From: Emma Avis [REDACTED]
Sent: 24 April 2019 10:27
To: Andrew Wood
Cc: Paul Broggi
Subject: RE: LU/91/19/PL Additional Highways Response from WSCC

Subject: LU/91/19/PL Additional Highways Response from WSCC

I have received a letter from Harbour Park who are concerned over the loss of the coach park area (site D). It's not clear from the Design and Assess Statement if this is a permanent loss over the summer season or just on a few days. The Local Highway Authority would advise that provision for coach parking is made elsewhere to avoid these vehicles parking and blocking the highway. Additional temporary directional signage should also be provided, directing coaches where to park whilst site D is unavailable.

SITE LOCATION PLAN AND
BLOCK PLAN - SITE C&D

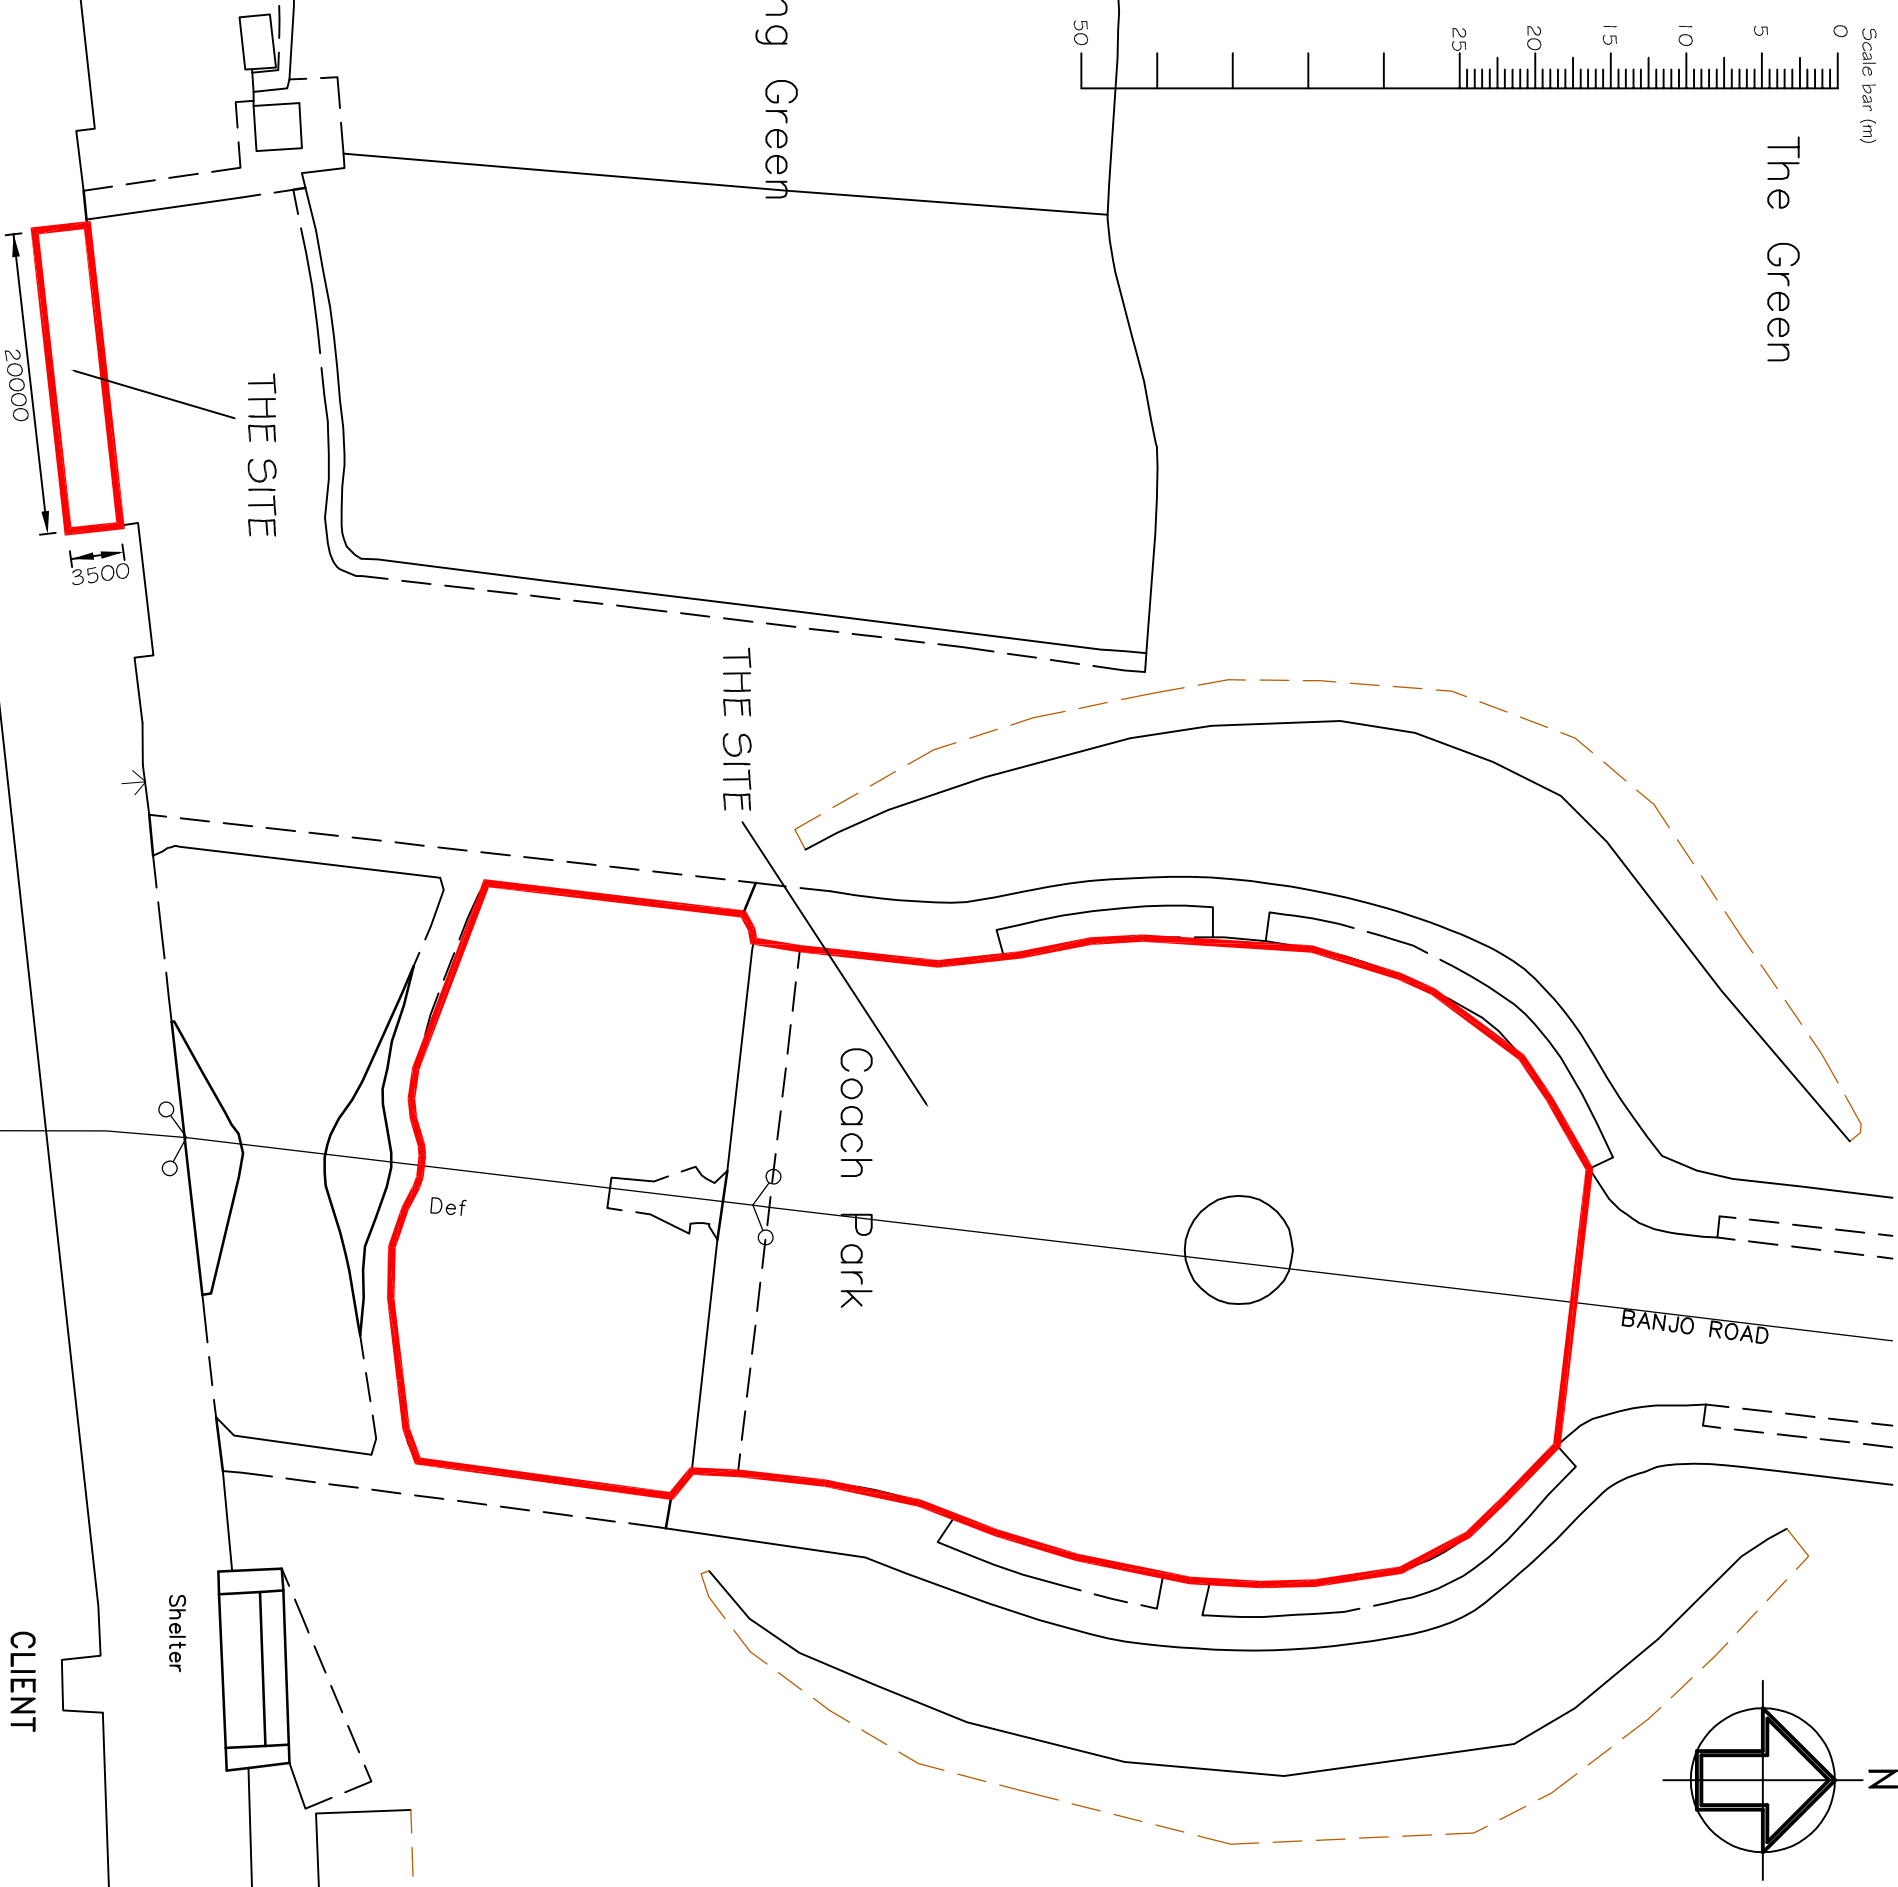
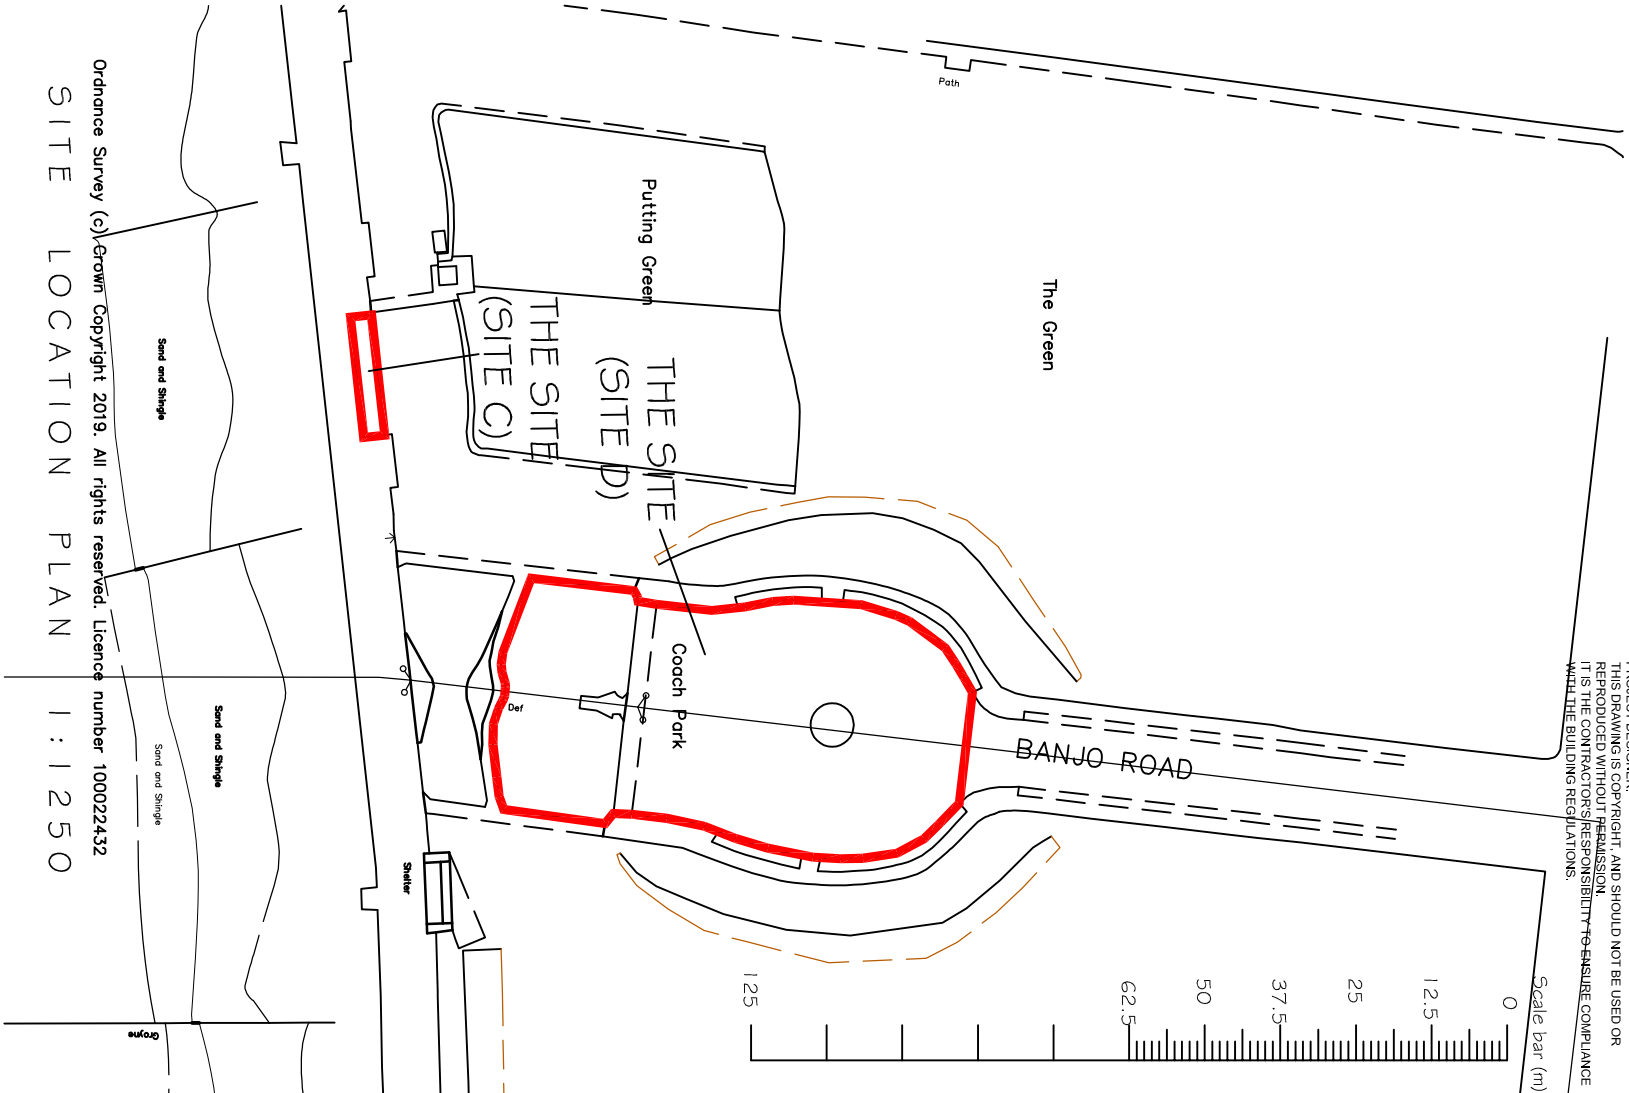
We would need to know roughly how many days. We would also expect to see alternative provision put forward by the applicant if they are removing all coach parking from this area. This should be demonstrated on a plan with some accompanying commitment to provided signage to direct the coach drivers.
